M60/M62/M66 Simister Island Interchange Project

Application by National Highways for an Order granting Development Consent for the M60/M62/M66 Simister Island Interchange Project

Summary Statement on behalf of the Hillary Family

FIGURE 2.3

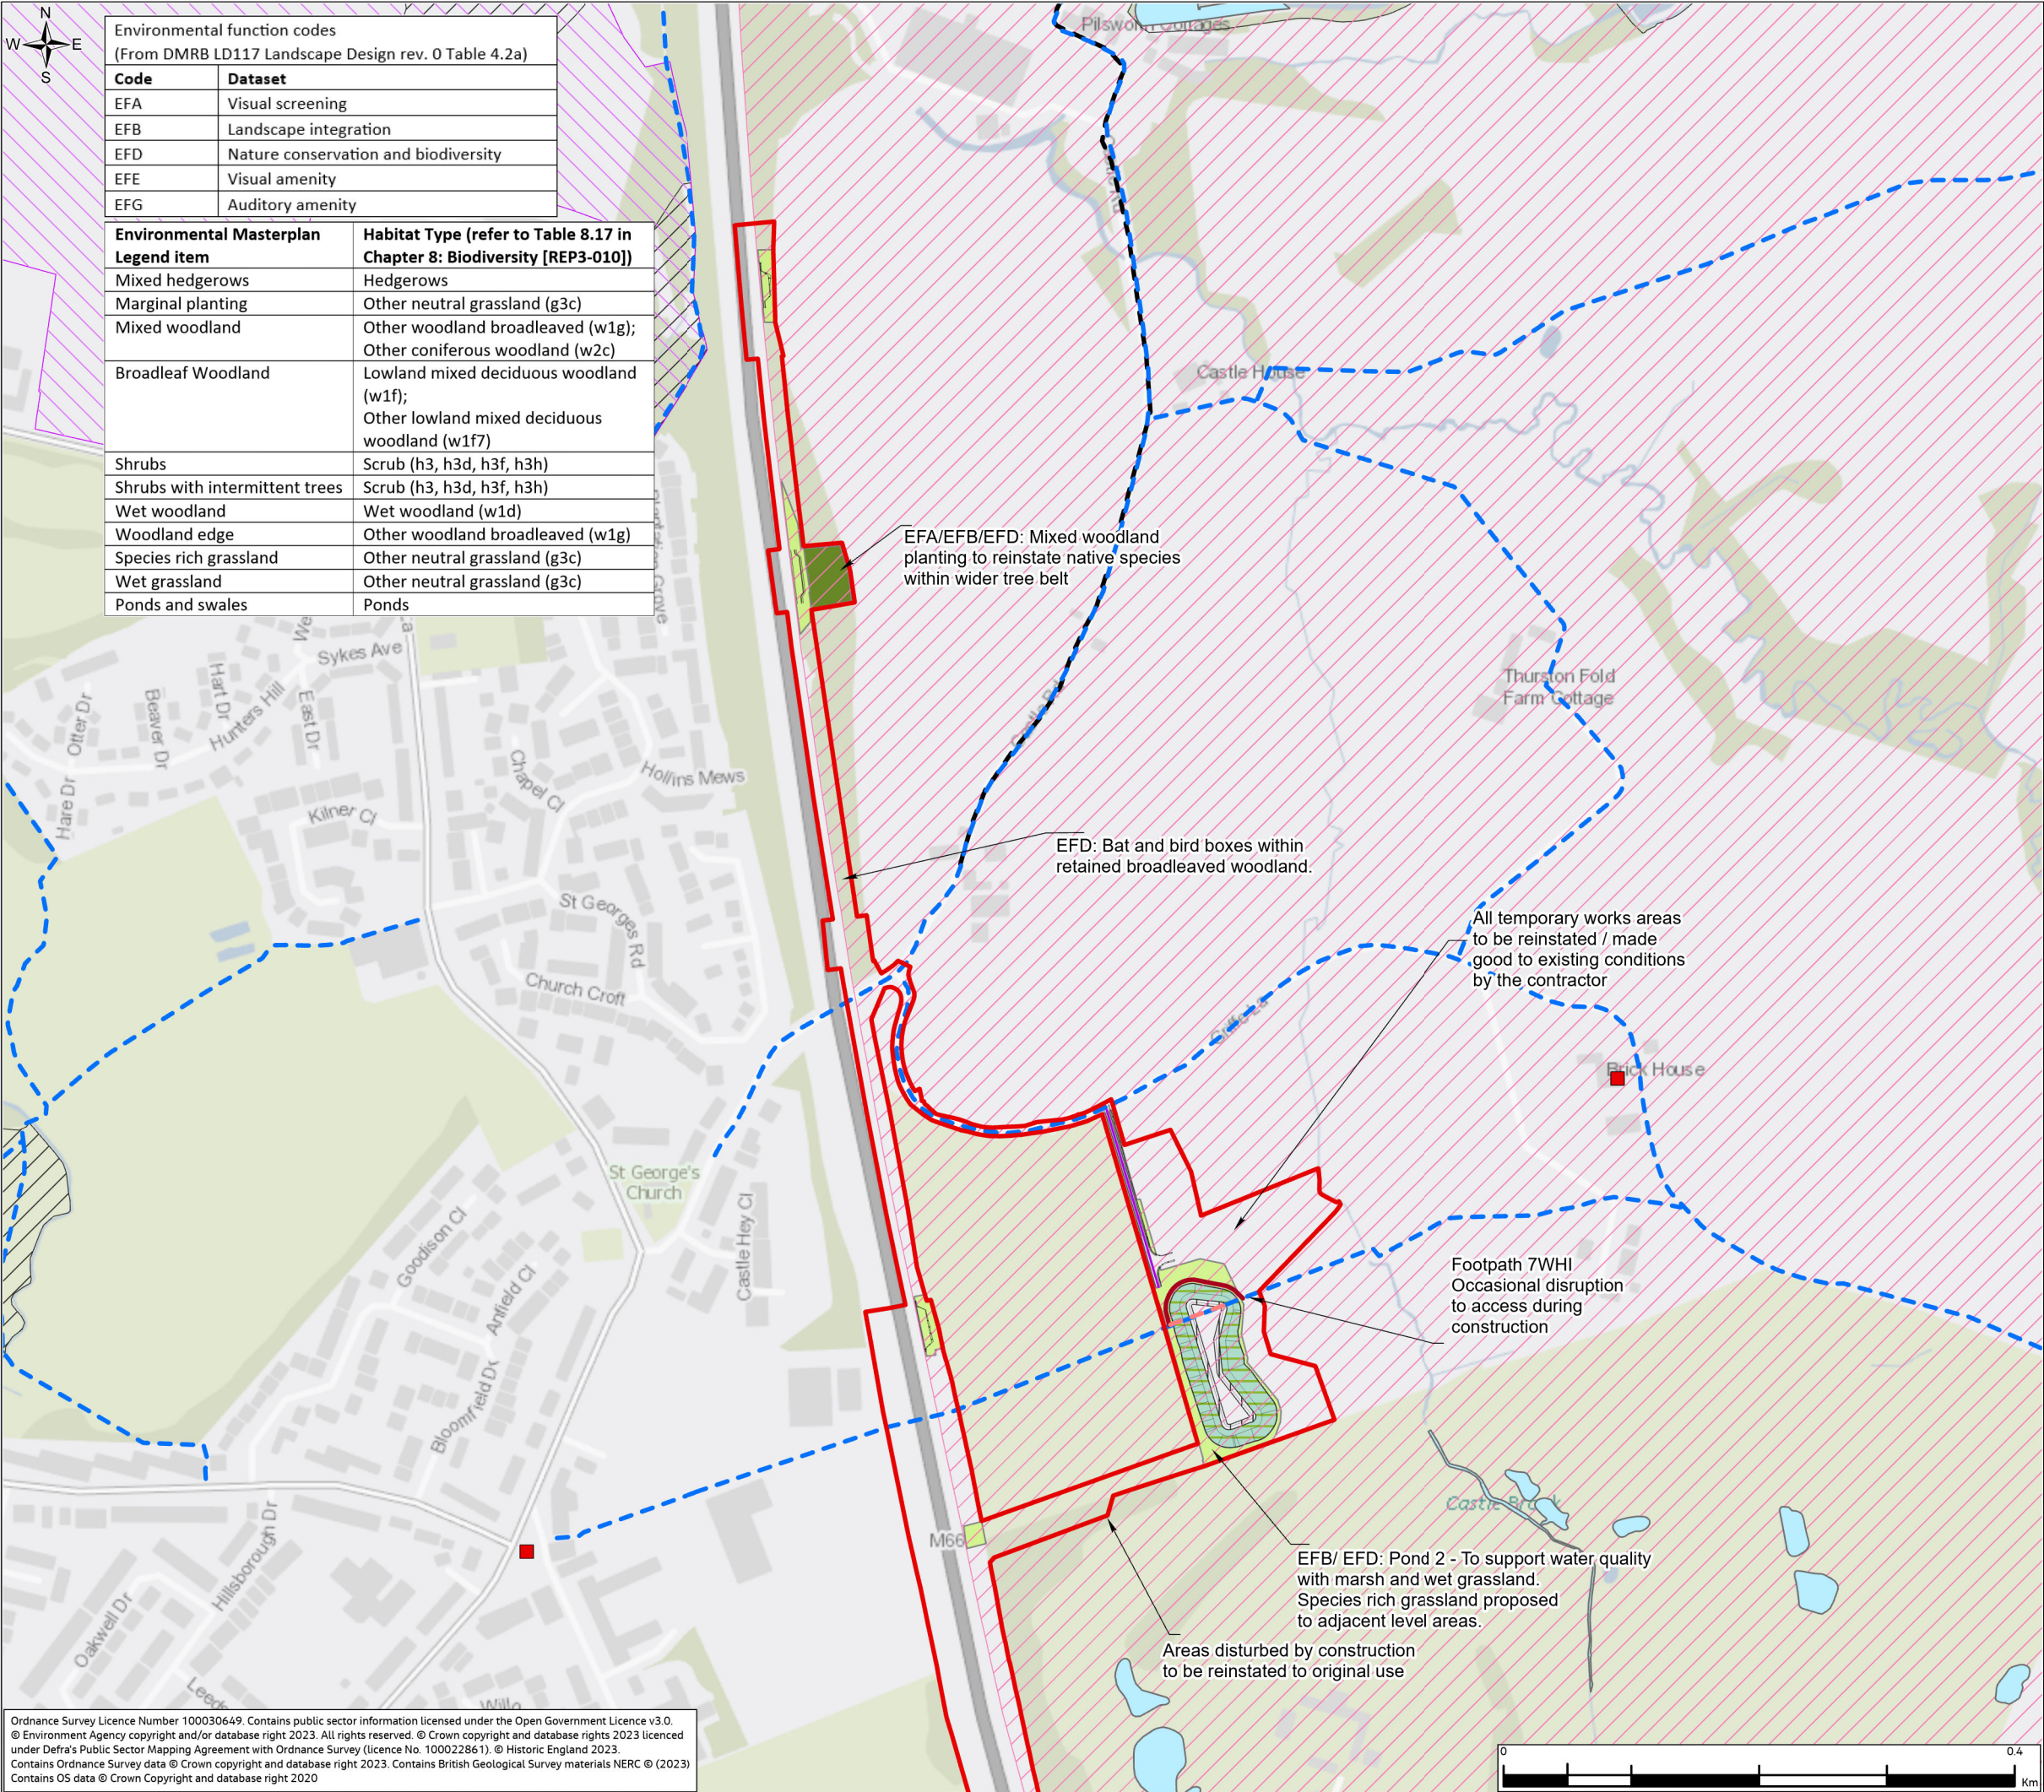
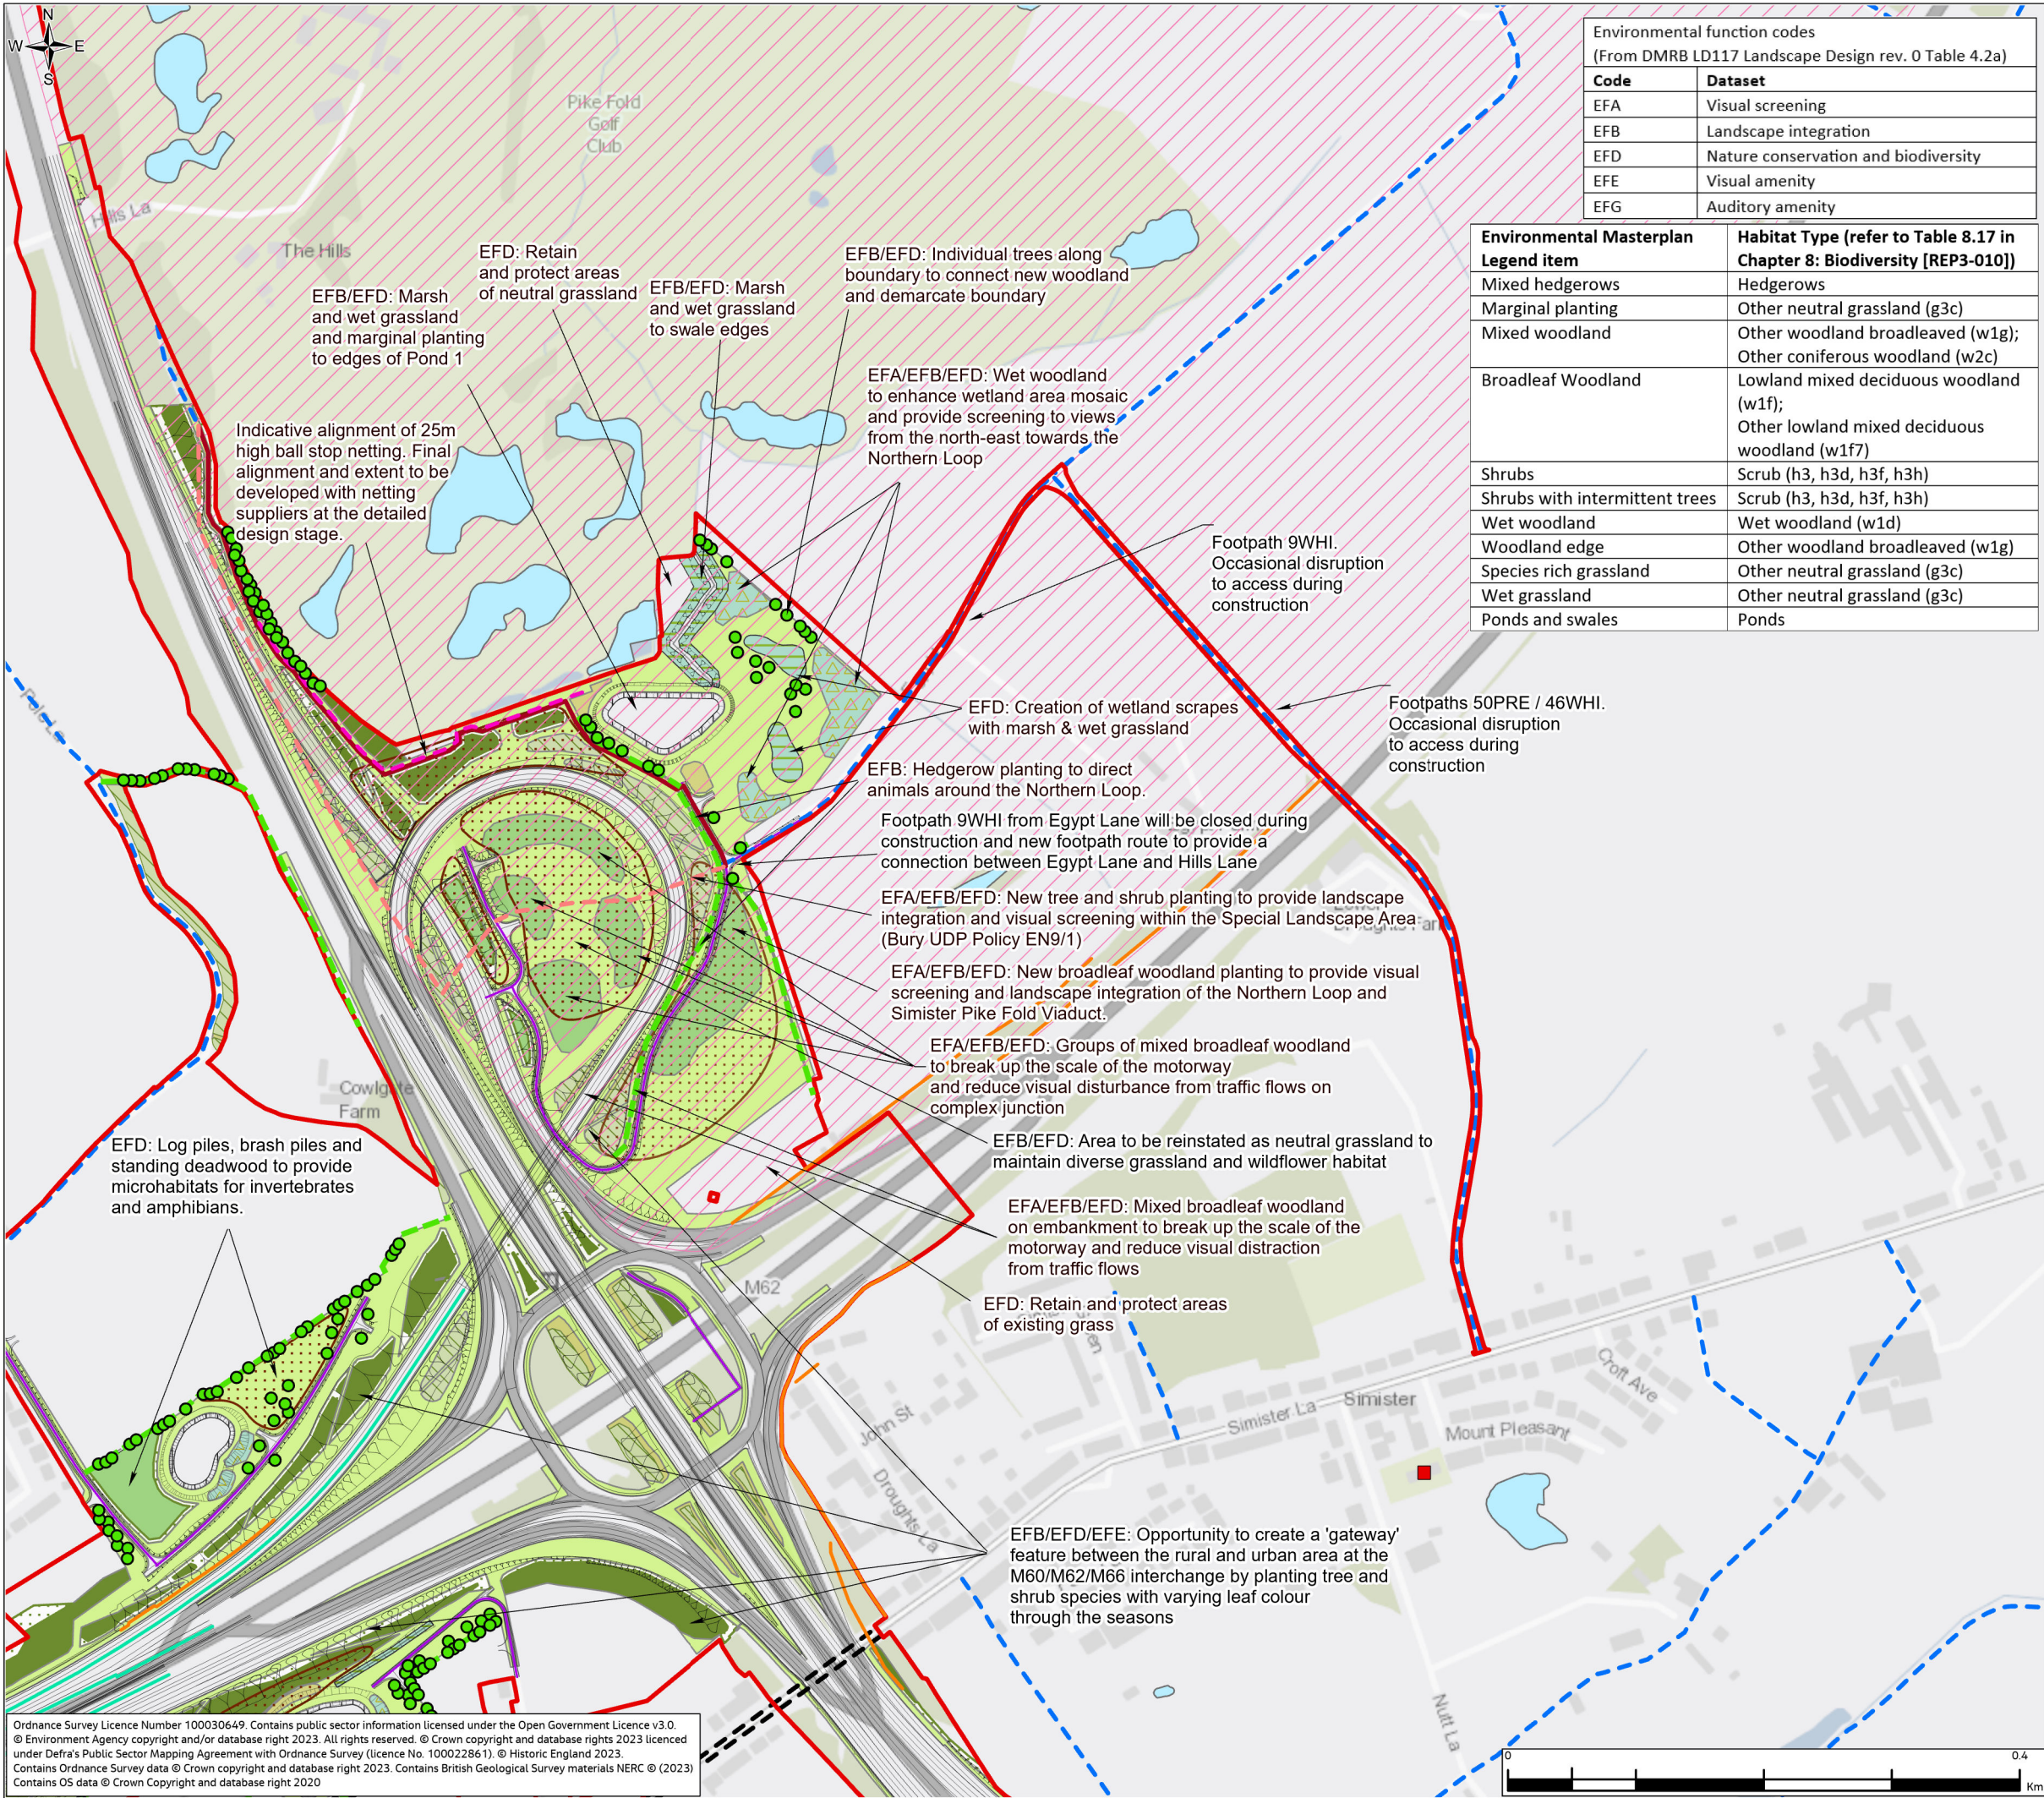
- i. Commitment LV5 relates to land adjacent to the EMAs. It is not relevant to the EMAs, and nor does it justify the need for powers to permanently acquire the EMAs.
- j. The Environmental Masterplan [APP-057] demonstrates that hedgerows can be provided on the Northern Loop embankments and/or along the existing Egypt Lane verge. Commitment LV6 does not justify the need for powers to permanently acquire, the EMAs themselves.

- k. Commitment LV10 relates to *the Northern Loop embankments and land within the Northern Loop*. It does not relate to the EMAs and does not justify the need for powers to permanently acquire the EMAs themselves.
- l. While Commitment LV15 does expressly refer to land east of the Northern Loop, it does not refer to the EMAs. The applicant considers that sufficient planting can be provided on the Northern Loop embankments so as to provide the mitigation described, and Commitment LV15 does not amount to a compelling justification for the powers sought in respect of the EMAs.

Similarly, the Hillary Family repeats and maintains its comments regarding attenuation pond 1 and its outfall drain, in that it considers these features could either be located inside the Northern Loop or drawn much tighter to the footprint of the Northern Loop so as to reduce the land take from the Hillary Family.
